TOWN AND COUNTRY PLANNING (CONTROL OF ADVERTISEMENTS) (ENGLAND)  
 REGULATIONS 2007

**Address: 10 Gees Court, London, W1U 1JJ,**

**Proposal: Display of a non-illuminated projecting sign measuring 50cm x 60cm; a non-illuminated fascia sign measuring 20cm x 90cm; and an awning measuring 470cm x 180cm.**

01 EXTERNAL ELEVATION - AWNING RETRACTED 1:100 @ A3

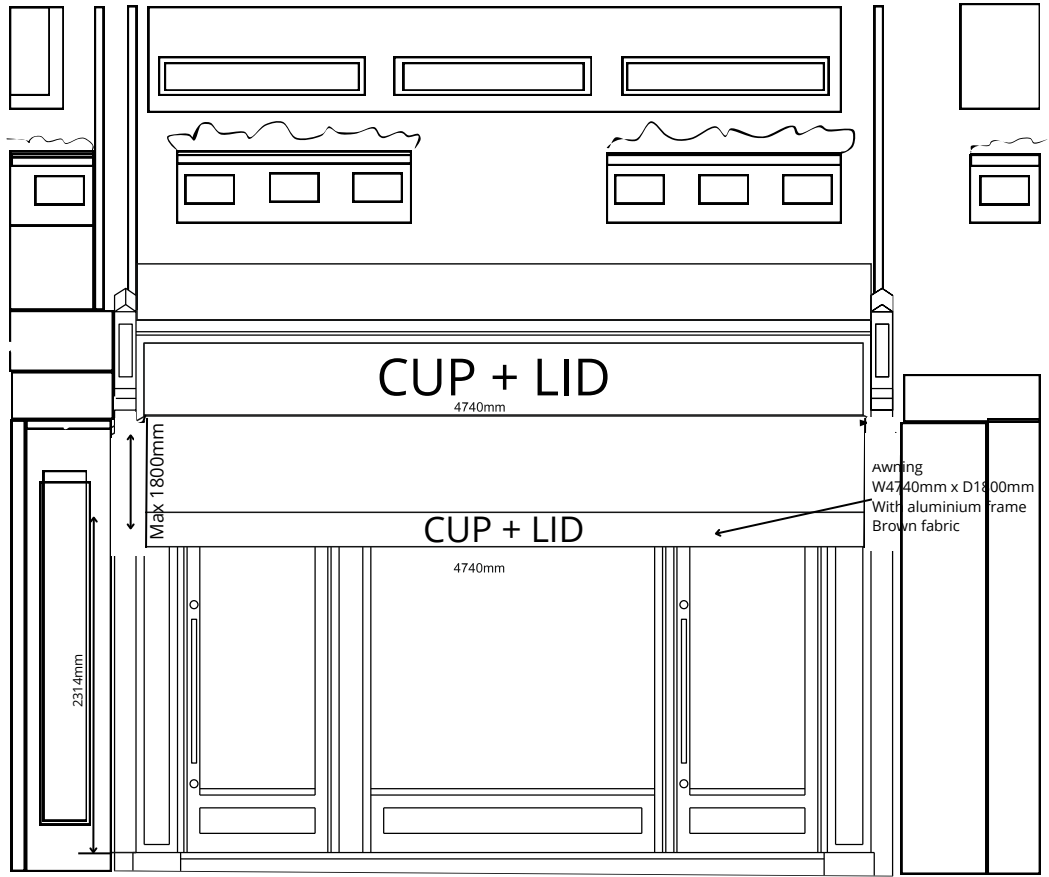
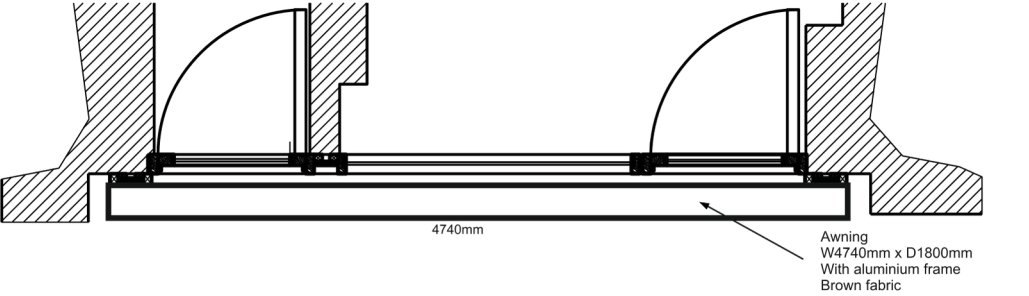
- 1 The proposed elevation shows a splayed awing wider than the shopfront. Please amend the drawing so that it shows a true elevation and remove the large arrows from the drawings unless they have some purpose in which case that needs to be explained.
